From: Clerk Elmesthorpe Parish Council <clerk.elmesthorpe@hotmail.com>
Sent: 17 August 2022 13:51
To: Planning Mailbox
Subject: fao Joe Fleetwood - application 22/0711/HH

Thank you for your letter of 27 July 2022 regarding application 22/0711/HH for two storey side extension, front canopy, two storey and single storey rear extensions with internal alterations and alteration to vehicular access at Acacia Stanton Road Elmesthorpe.

Proposed
Site Block Plan

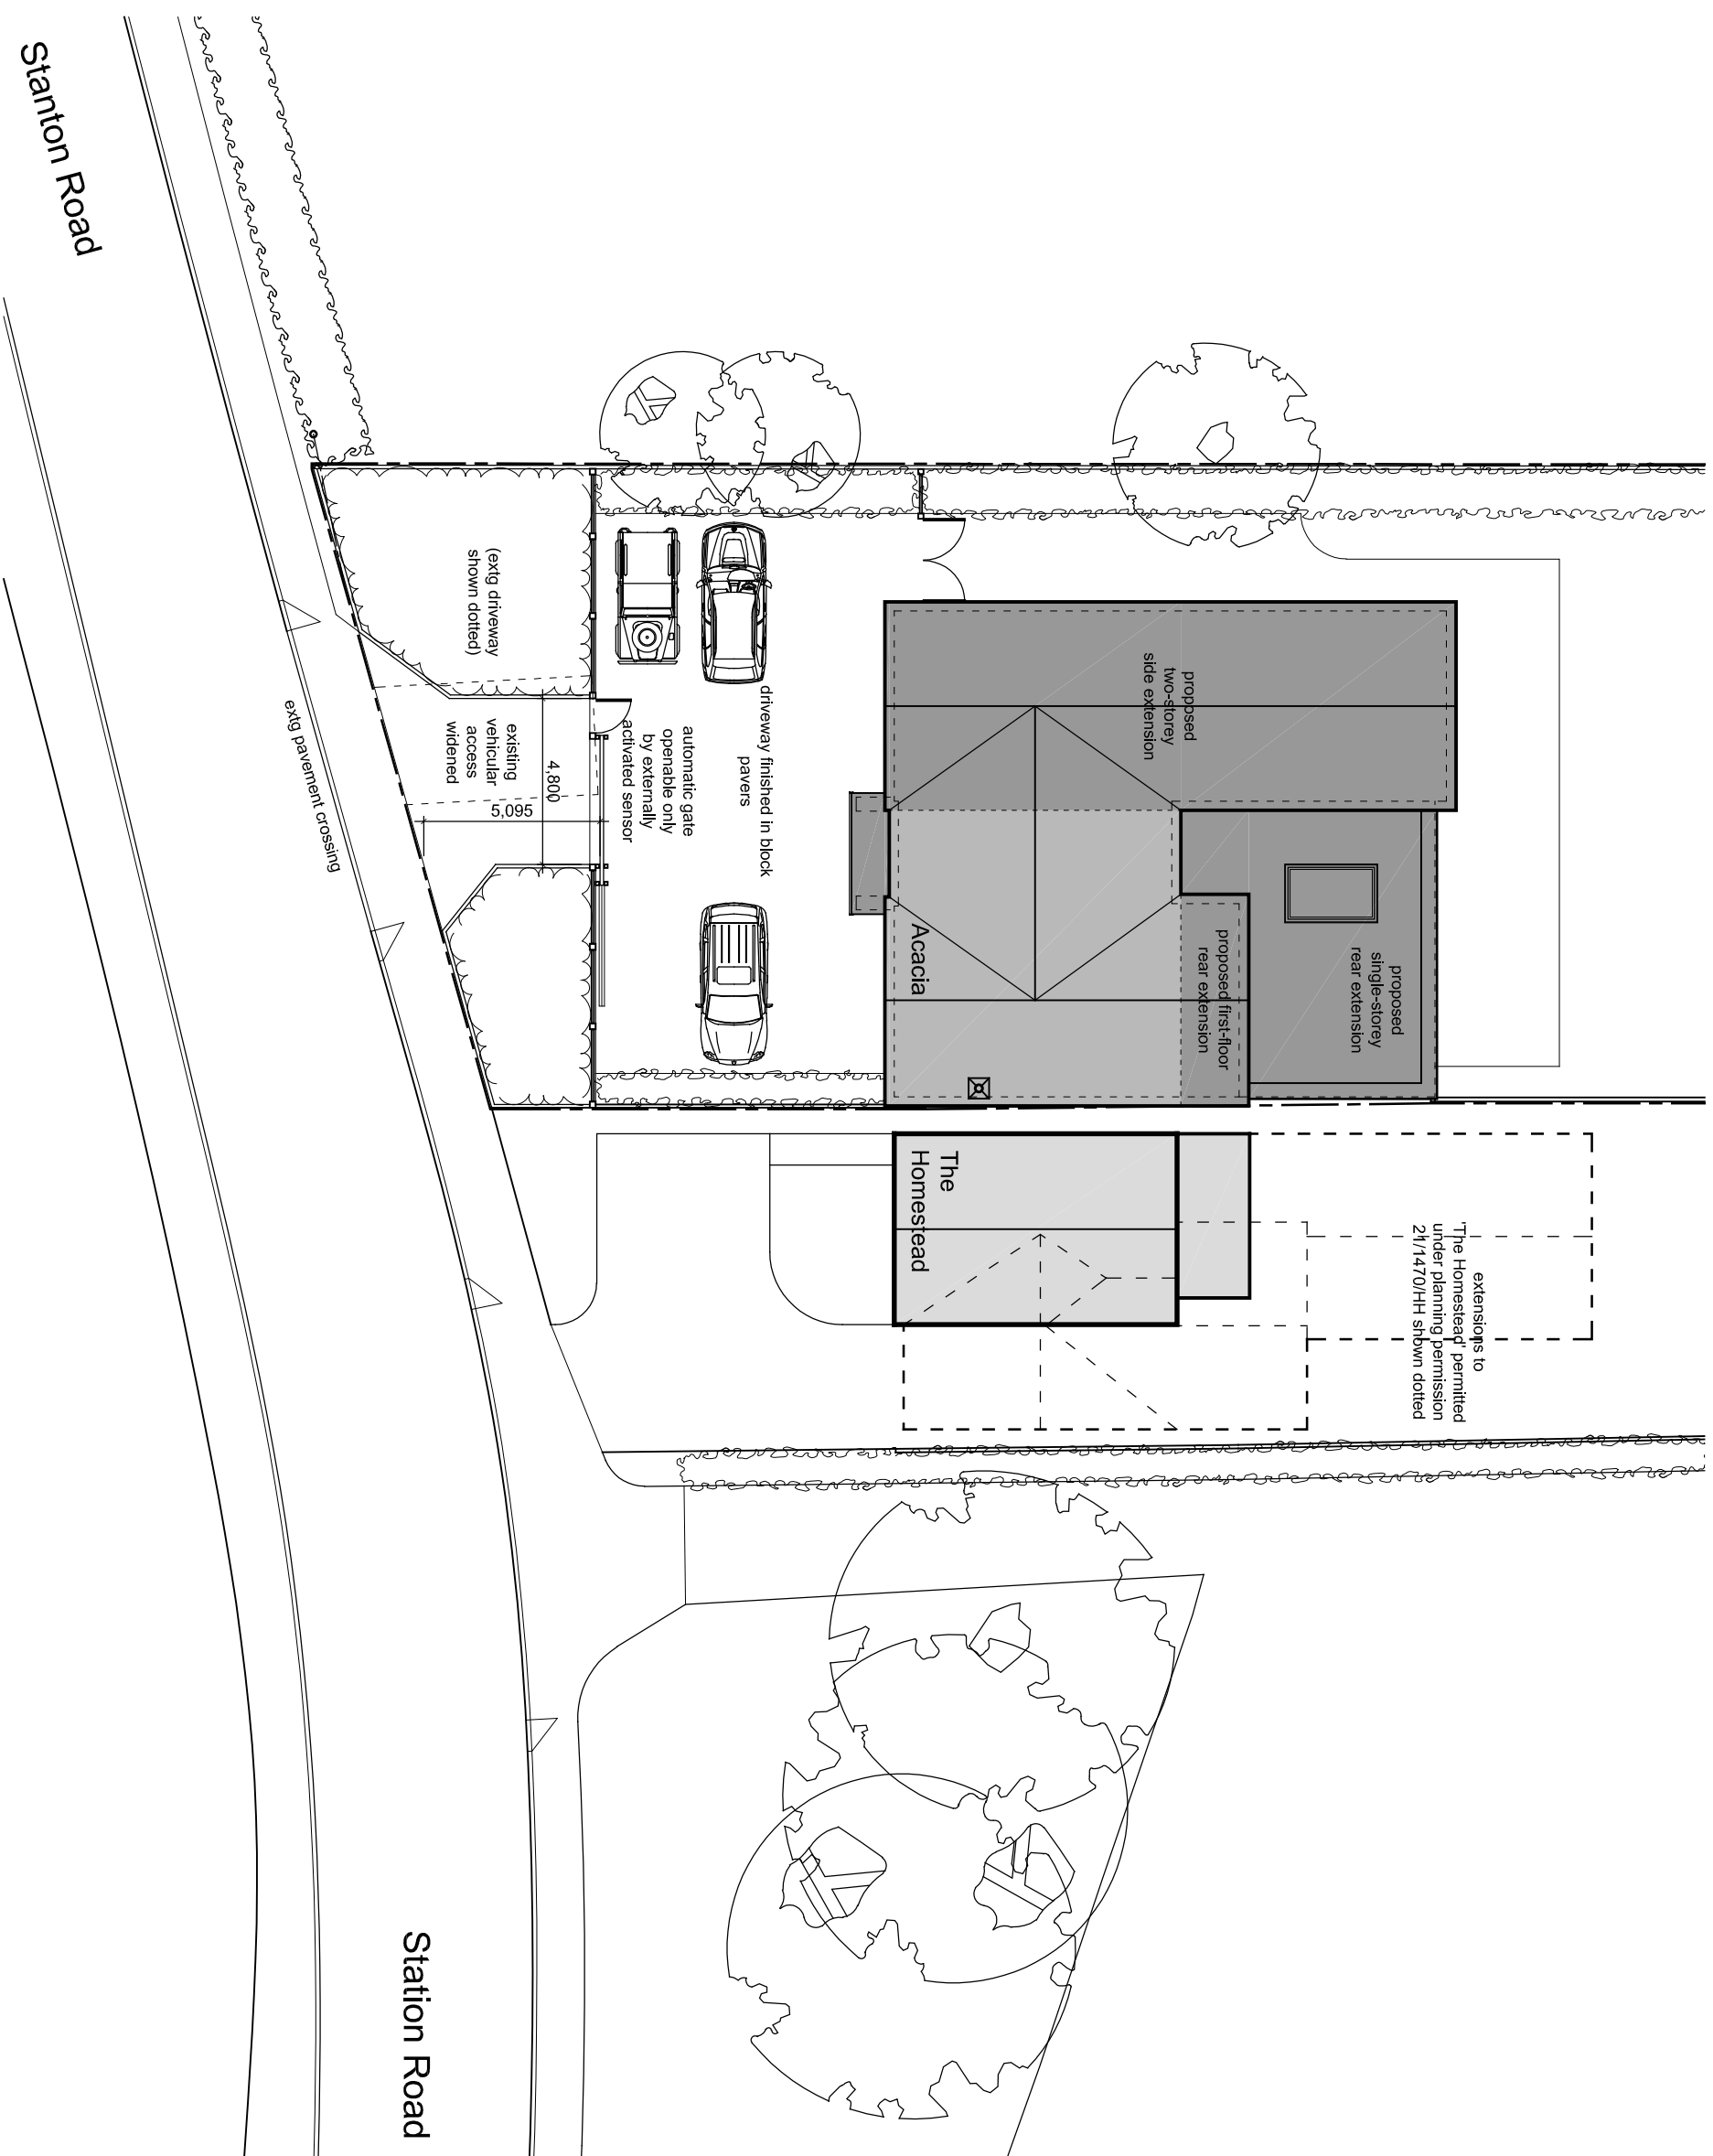
However, in the light of the fatal road accident in January 2019 on the bend on which this property is situated, the Parish Council wishes to object in the strongest terms to proposed alterations to the vehicular access on highways safety grounds.

The applicant is proposing to install an automatic gate openable by externally activated sensor at 5.095m from the highway. If the gate does not open, or if access to the property is sought for two vehicles at the same time, there is the risk that the tail end of vehicles will be on the highway or the risk of vehicles queued on the highway. There is also the issue of how the gate will operate in terms of light commercial vehicles bringing home deliveries.

There is a white line in the road outside the property as an advisory to vehicles not to overtake at this point due to the proximity of the blind bend. However, should there be any issue with the operation of the gate, vehicles travelling from Elmesthorpe towards Stoney Stanton will have no option but to overtake in the face of oncoming traffic coming round the blind bend from Stoney Stanton towards Elmesthorpe.
